Project Name **SOUTHWEST GASTROENTEROLOGY**

1. **Project # 1004909**
06DRB-00930 Major- SiteDev Plan BldPermit

DEVELOPMENT REVIEW BOARD – SPEED MEMO

CITY OF ALBUQUERQUE
PLANNING DEPARTMENT
DEVELOPMENT REVIEW BOARD

SHEET TITLE:
**DEVELOPMENT REVIEW BOARD
 SITE UTILITY PLAN**

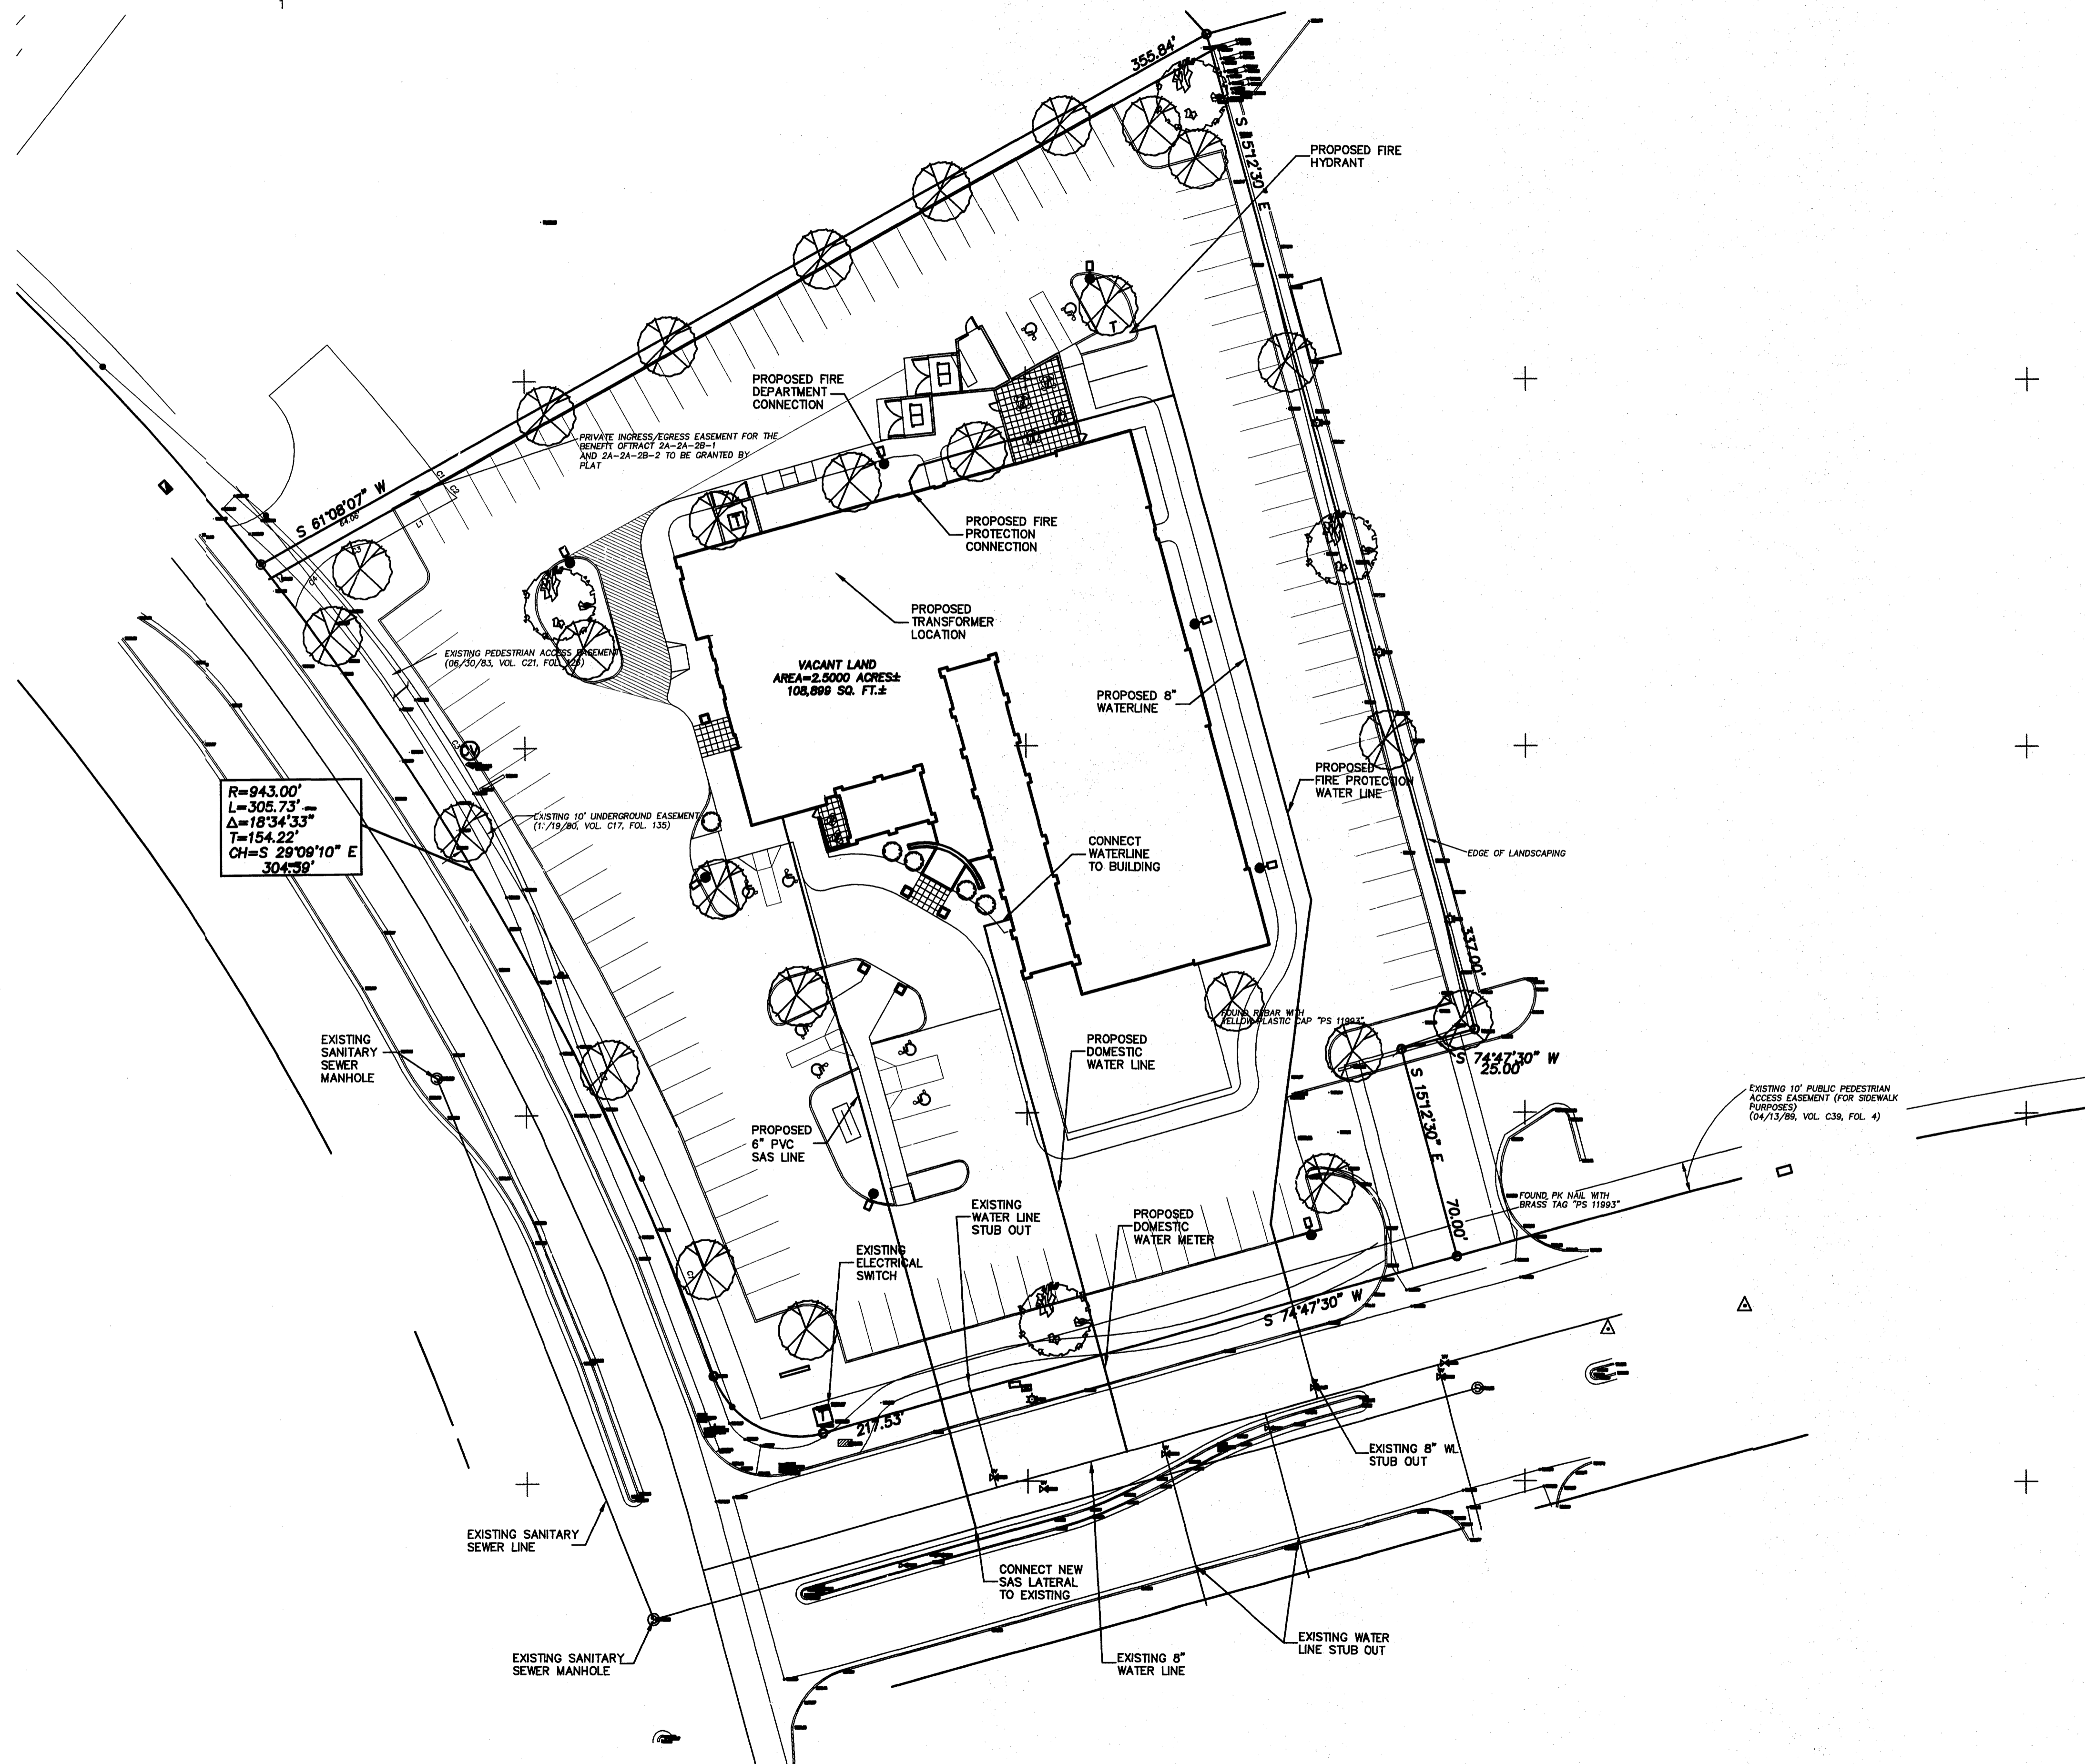
Utility Plan needs more detail, such as water meter size, fire line sizes, show new hydrant locations, and clarify that sewer service connects to an existing stub. Need a copy of the Fire Flow calculation sheet from the Fire Marshal.
